From: Kathryn Welch
Sent: 16 June 2022 10:17
To: Planning Scanning
Subject: FW: Beech Place, Torton Hill Road AB/43/22/HH

From: Kathryn Welch [REDACTED]
Date: Thursday, 16 June 2022 at 10:02
To: Adam Casey [REDACTED]
Subject: Beech Place, Torton Hill Road AB/43/22/HH

Before the site is occupied or any machinery is introduced to the site or demolition work or construction work or alterations to existing ground levels takes place a PRE COMMENCEMENT Site Meeting is to take place between the Planning Authority's Tree Officer and the Arboricultural Expert representing the site owner(s) - at this meeting all protective fencing will be inspected to verify it is 'Fit for Purpose' as required under British Standard 5837:2012 and has been erected and positioned exactly as shown on the Tree Protection Plan contained within Appendix 6 of the Arboricultural Report – April 2022.

35a Torton Hill Road
Appendix 6 - tree protection plan

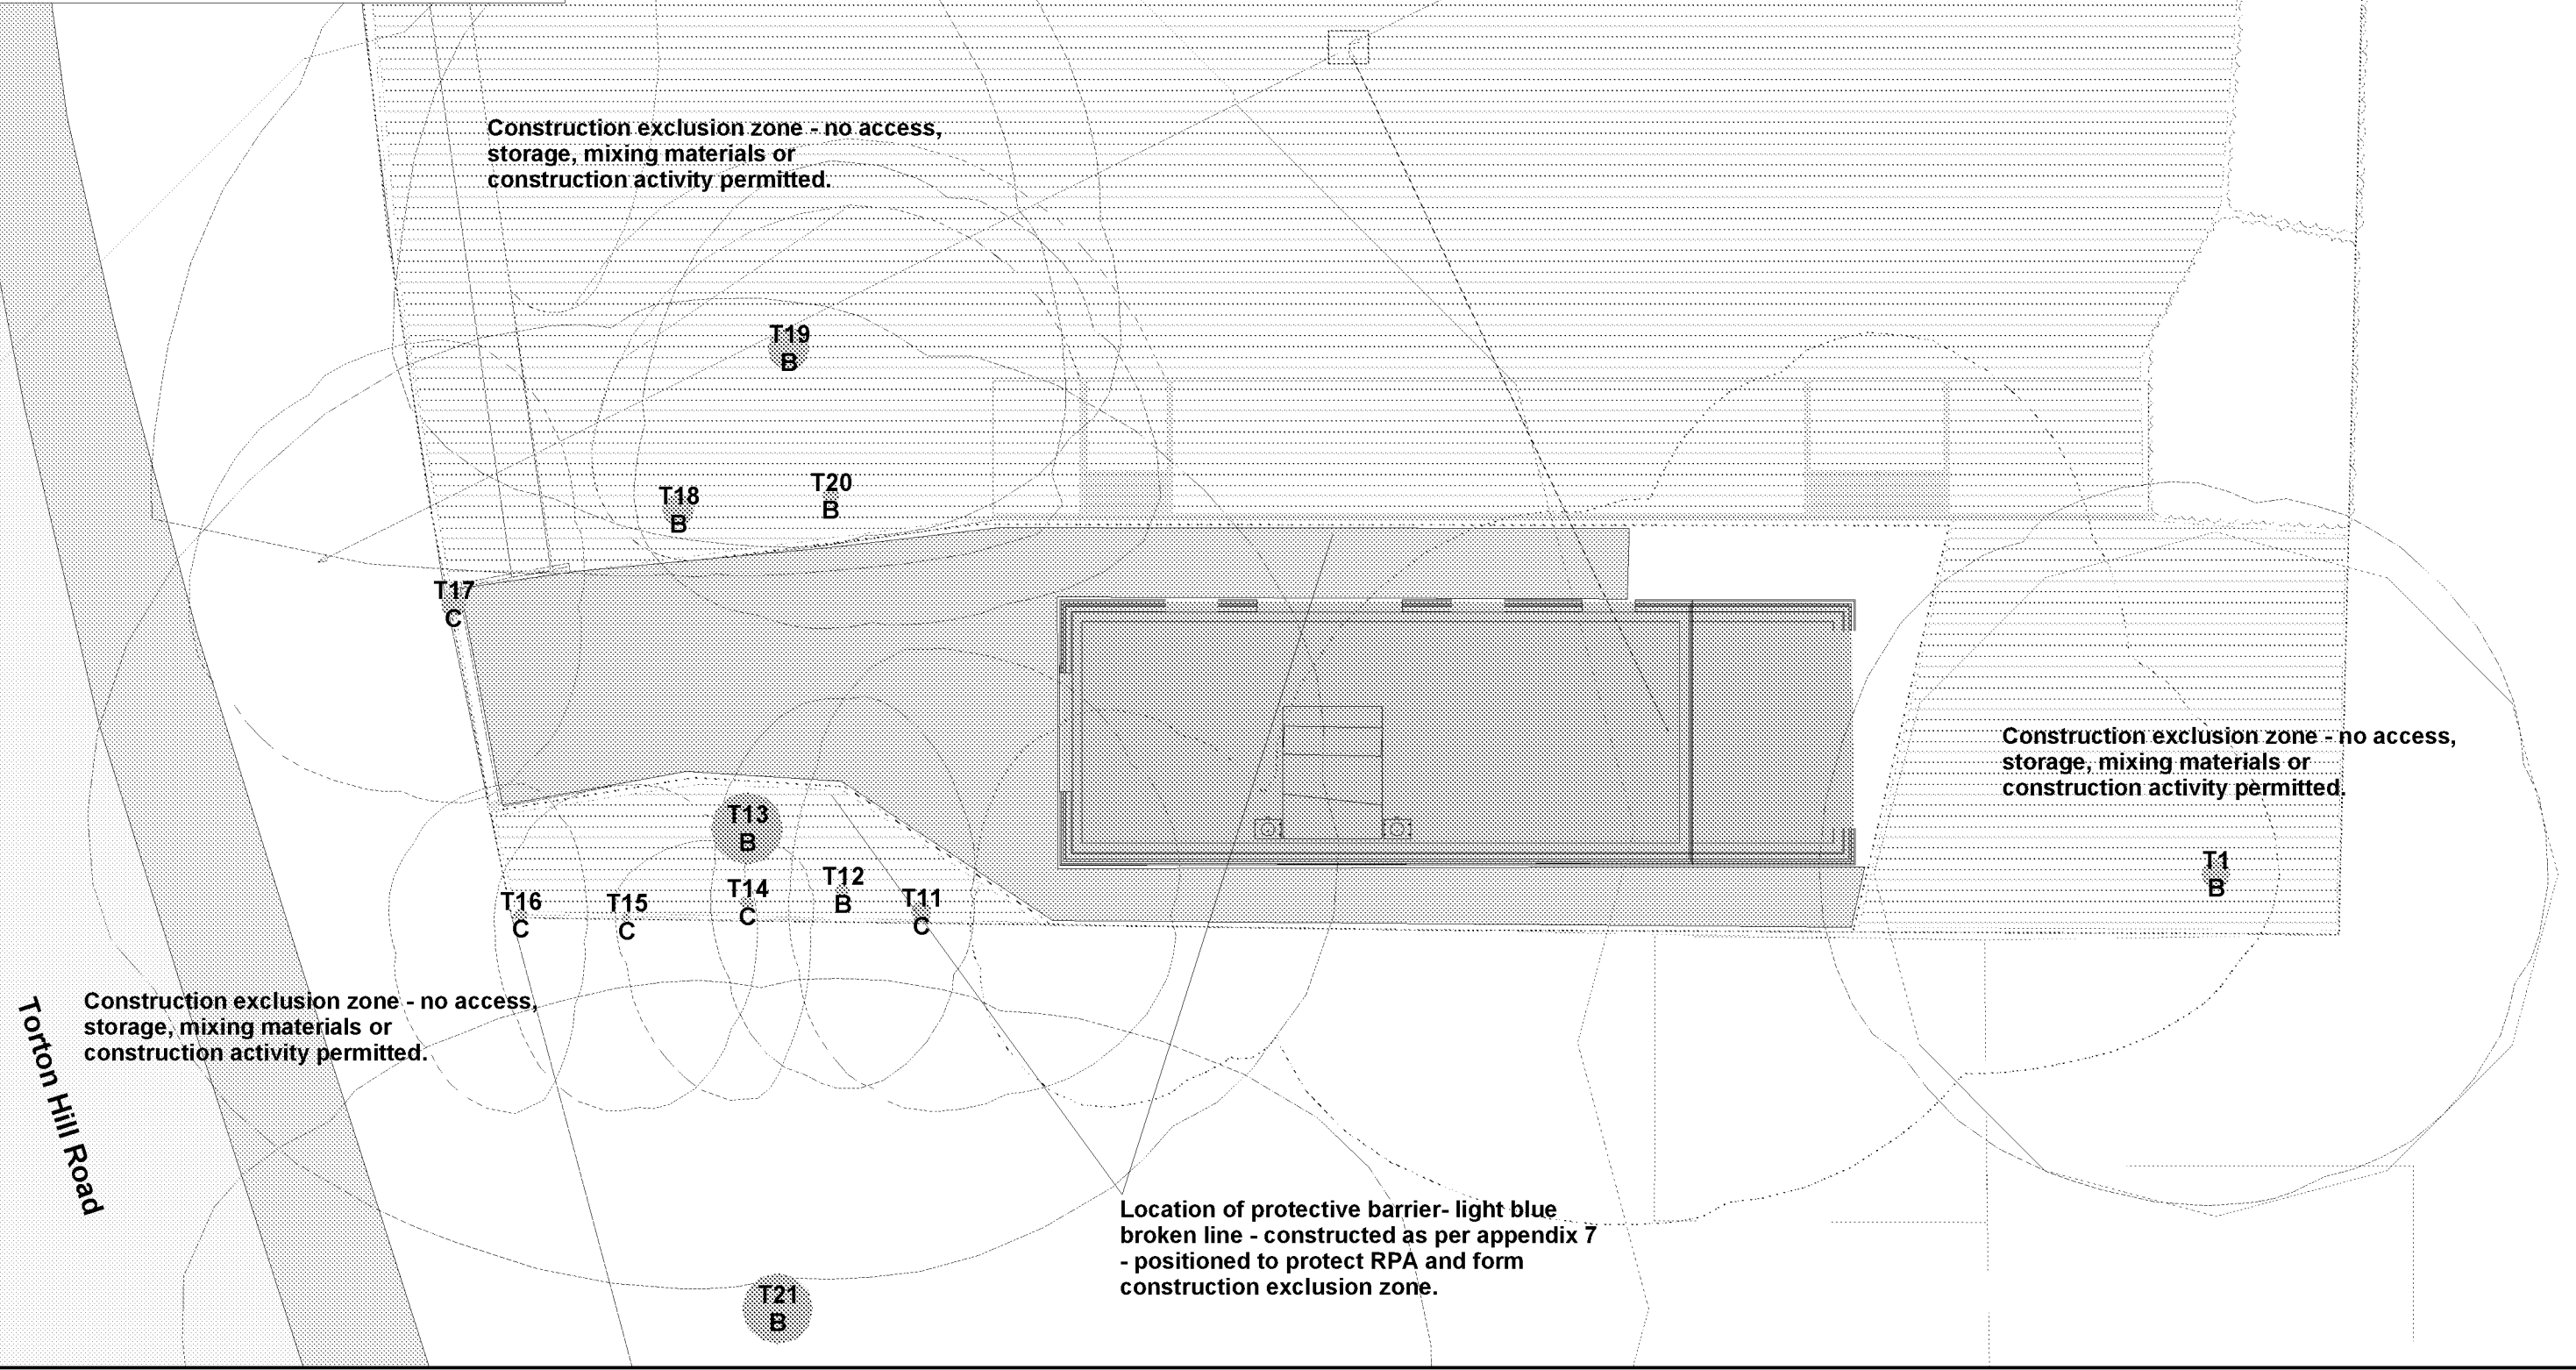
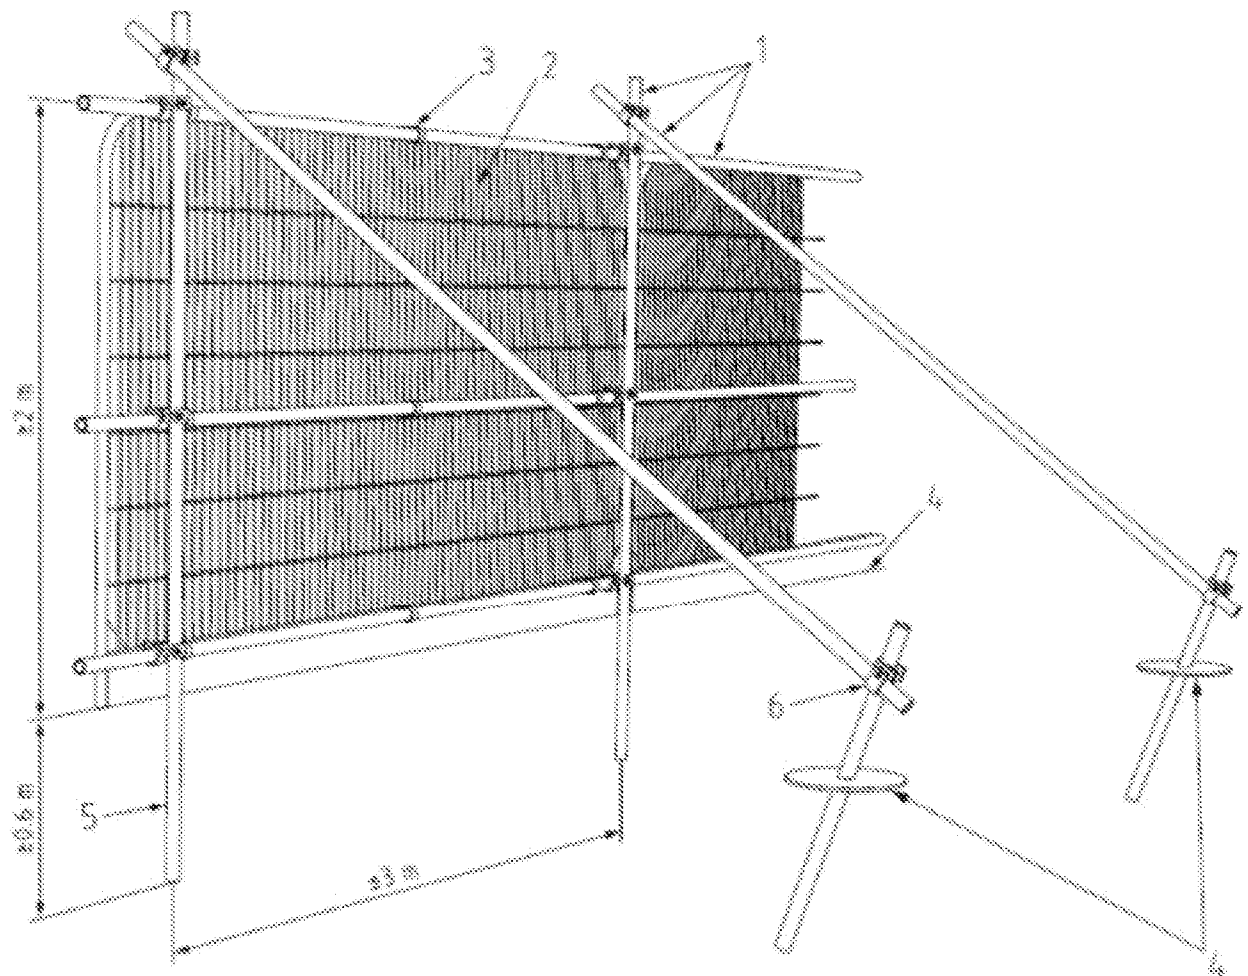
A schedule of Site Monitoring/Supervision visits and Reporting Procedures prepared by an Arboricultural Expert will be required and their extent will be agreed on at the site meeting to the satisfaction of the Planning Authority's Tree Officer.

Yes this is understandable and acceptable.
